RE: HASTINGS SECONDARY COLLEGE PORT MACQUARIE CAMPUS UPGRADE  
APPLICATION SSD-11920082  
16 OWEN STREET PORT MACQUARIE  
COUNCIL AREA: PORTMACQUARIE-HASTINGS

## SUBMISSIONS IN RESPECT TO

HASTINGS SECONDARY COLLEGE PORT MACQUARIE CAMPUS UPGRADE  
APPLICATION SSD-11920082

16 OWEN STREET PORT MACQUARIE  
COUNCIL AREA: PORTMACQUARIE-HASTINGS

8 3D VIEW CAPA From Owen St

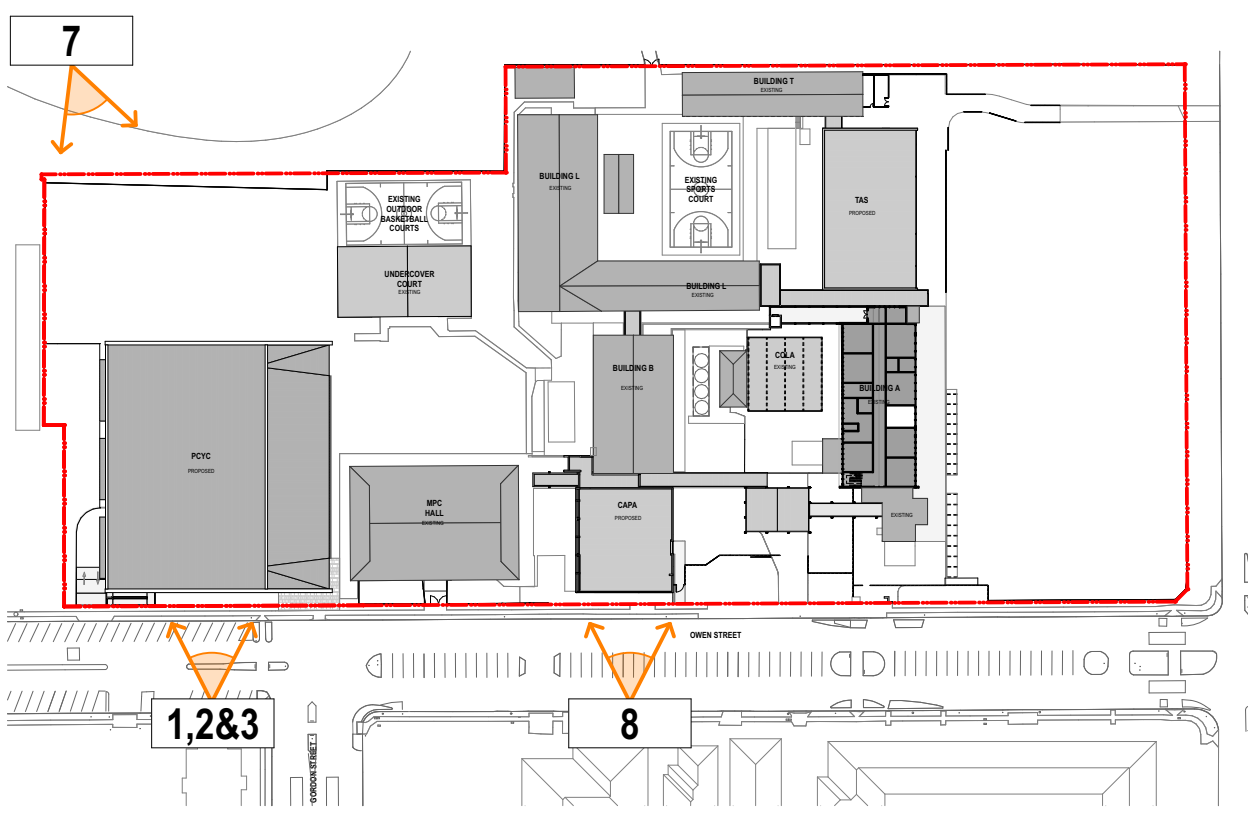
In stark contrast to this natural outlook, is the developer's outlook, looking at the proposed CAPA building from Owen Street, which is visually unacceptable:

Another major concern is the failure to take into account the privacy of the Mainsail Building residents who reside, or have tenants living in the apartments facing direct across from the proposed CAPA building. As illustrated from the developer's illustration above, the CAPA structure will have virtually ground to rooftop windows directly looking into the living rooms of those apartments facing Owen Street. The privacy of the Mainsail residents will no longer be secure especially at night, given that the proposed CAPA building is earmarked to be used outside school hours for creative and performance art activity.

Having regards to the current structures within the College, the proposed building will be visually intrusive and not in keeping with the rest of the existing College buildings. Further, the existing structures within the College are set back from the boundary fence thereby allowing for a natural visual barrier between the structures and Owen Street. In the proposed development plans for the CAPA building, there is little or no provision for any natural flora to reduce the visual impact of the building. In contrast, the existing trees have provided the residents of Mainsail with a natural and bush like view for many years.

I strongly urge that you do not approve this application in its present form, and strongly urge that the PCYC be relocated to another part of Port Macquarie and, that the CAPA building be relocated to the eastern end of the current playing/sports field, where it will still be able to provide the needs of Hastings Secondary College and eliminate all the concerns of the residents of the Mainsail Building.
